Historic England

25th January 2021

AQUIND Interconnector Project – The Examining Authority’s Second Written Questions and requests for information (ExQ2) Issued on 7th January 2021

Planning Inspectorate Ref: EN20022

File name: C:\USERS\UKPW03\DOCUMENTS\FIGURE 15.48A-48A - INDICATIVE LANDSCAPE MITIGATION PLAN OPTION B(ii) P03.DWG

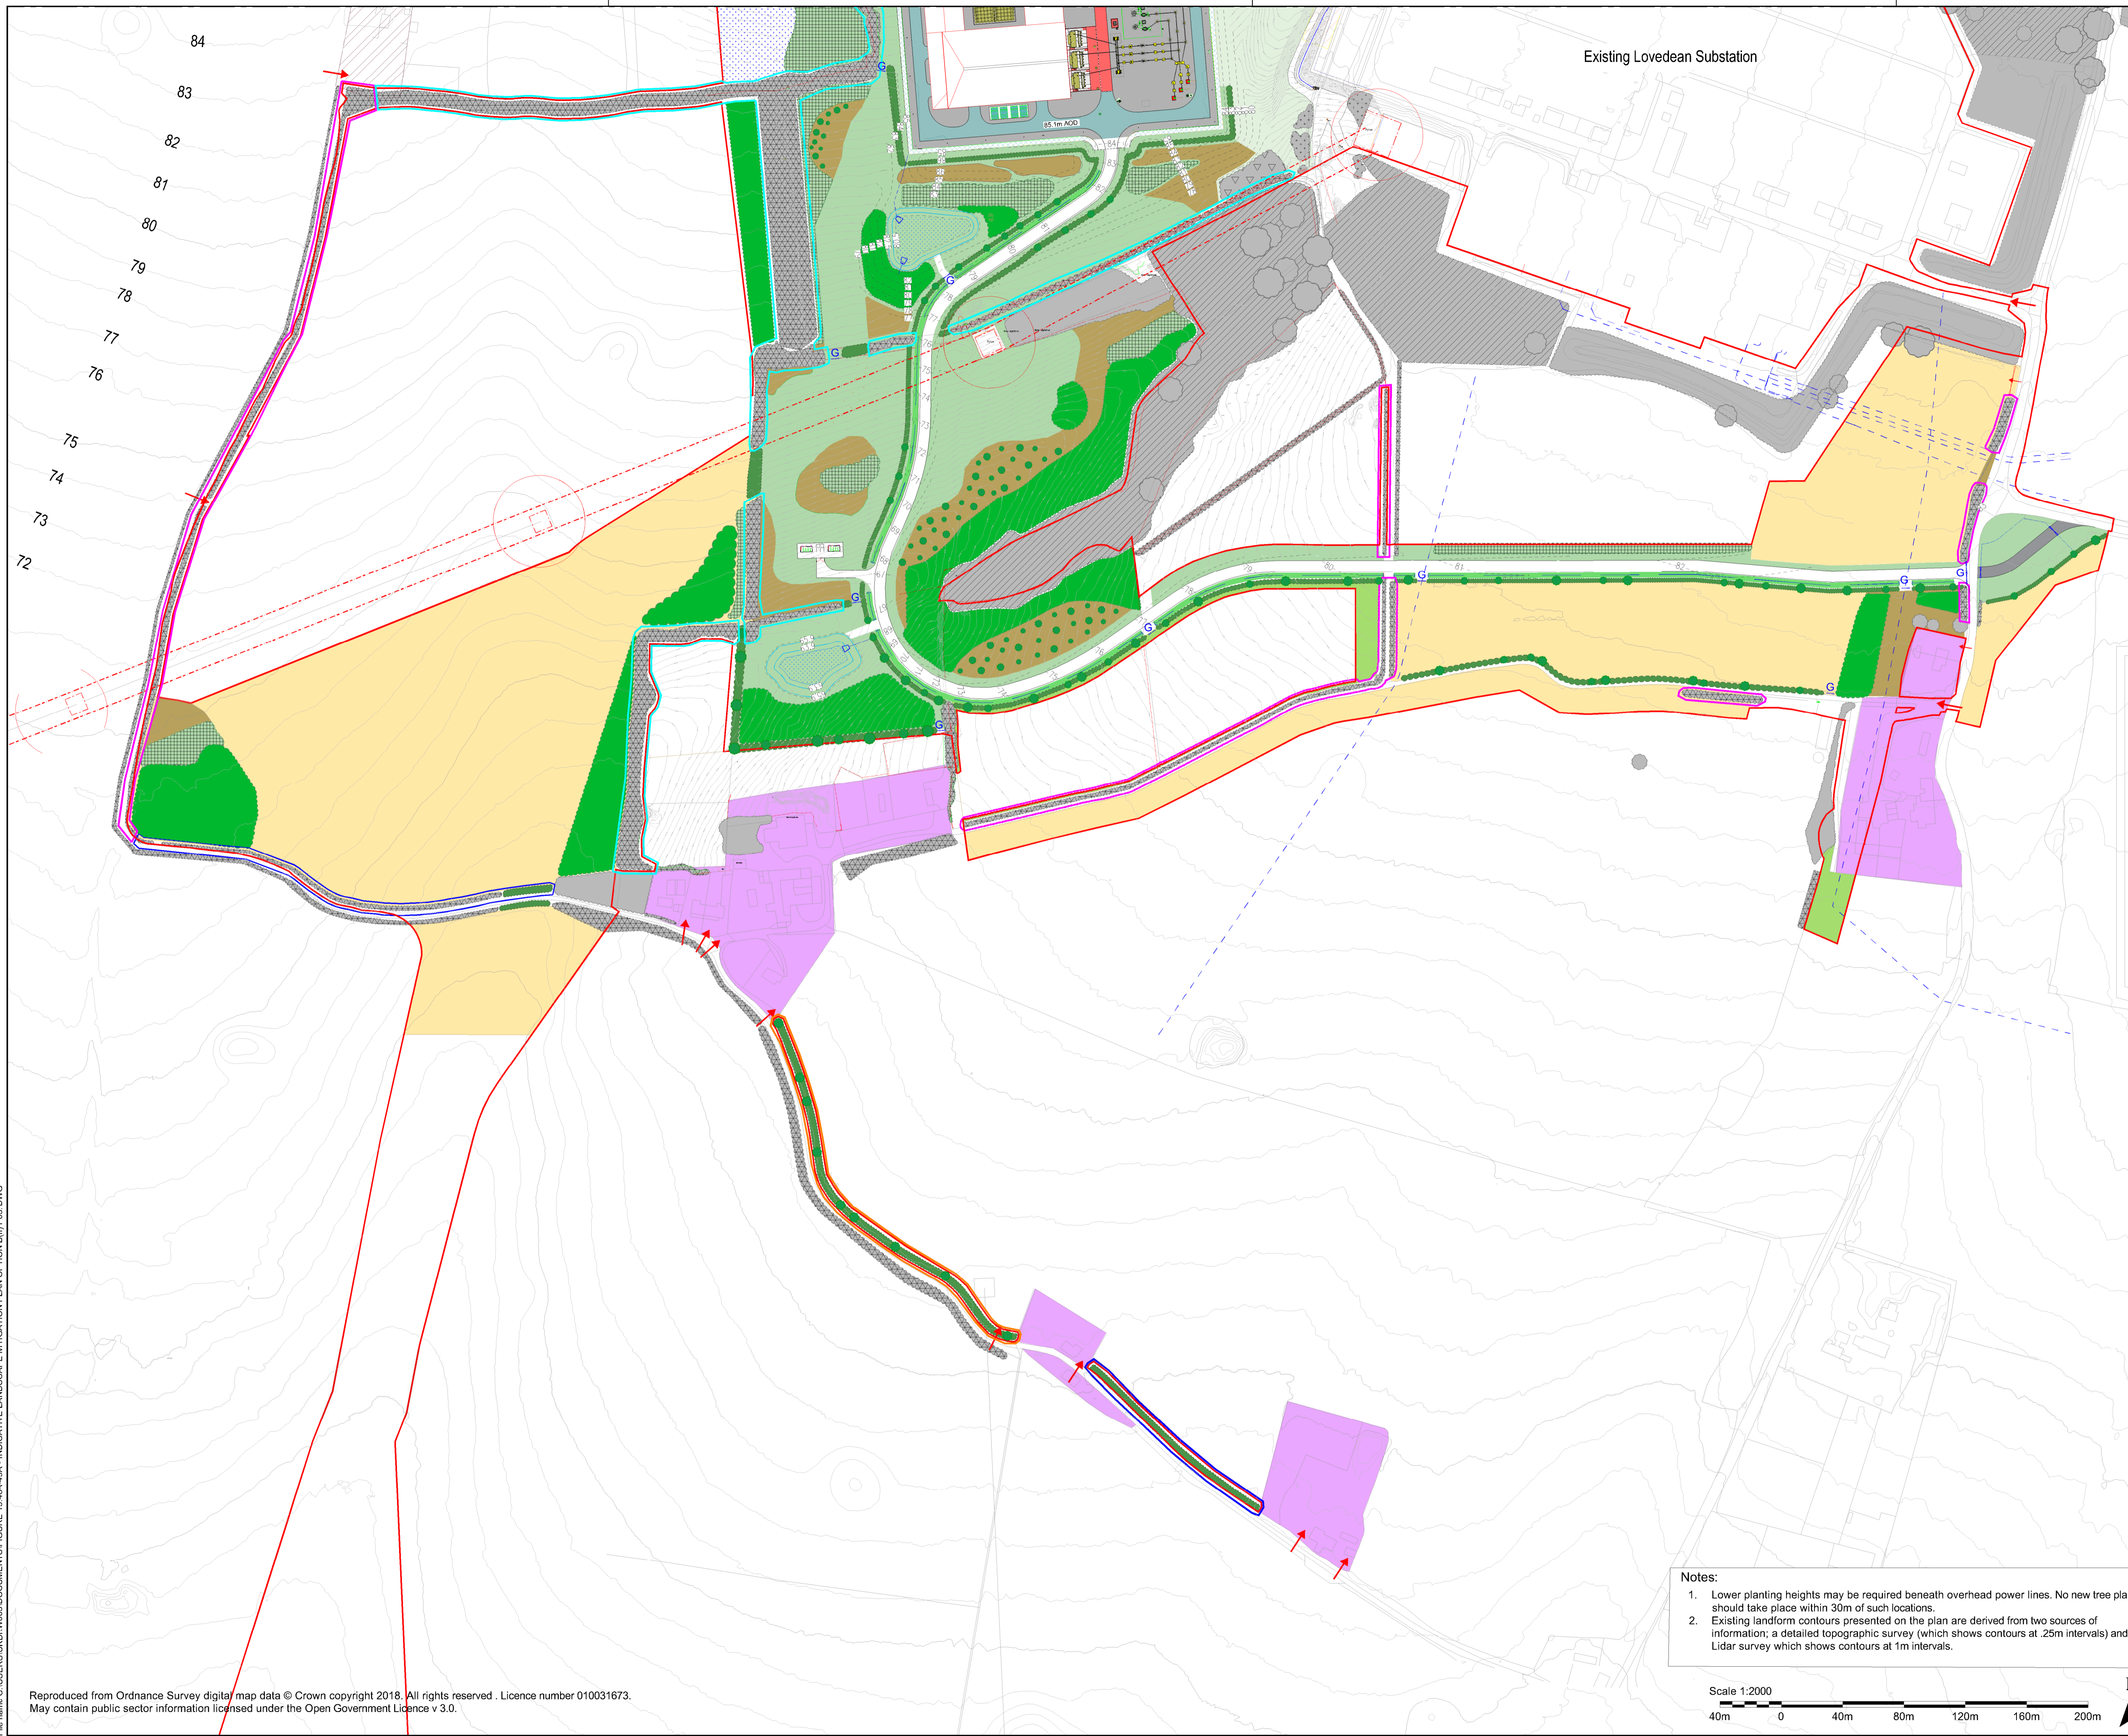
“How would the Proposed Development affect such significance and the future value and understanding of the asset? Would mitigation planting itself affect the significance of the asset’s setting?”

The field of fire to the west and south west is therefore of illustrative historic value. Such a value is dependent on visibility and has the power to aid interpretation of the past through making connections with, and providing insights into past activities at particular locations.

It is noted, however, that the field of fire (which would have extended some significant distance to the west) has been diminished by 20th century development, beyond and surrounding the proposed location of the ORS building and proposed landscape mitigation. Although it could be said that this lessens the strength of its illustrative historic value, it does not completely negate it as a contributing element of

the significance of the Fort. The proposed building itself is of relatively limited scale and at a reasonable distance from the Fort (in comparison to location and massing of surrounding development).

The impact of the proposal on the illustrative value and overall significance of the Fort is therefore perceived by Historic England to be no more than a moderate level of less than substantial harm. The specific element of harm, in relation to the experiential experience of the Fort and its field of fire, lies in the proposed positioning of the ORS building within the chosen area of land (the car park). With its proposed height and location the building will likely obstruct the view of Fort Cumberland Road from the western defences of the fort, thereby diminishing the illustrative connection between the fort and its role in providing defence along key historic land routes.

It is possible that mitigation planting, although softening the appearance of the building, could have the same impact, particularly if it were to obstruct views in the same manner.
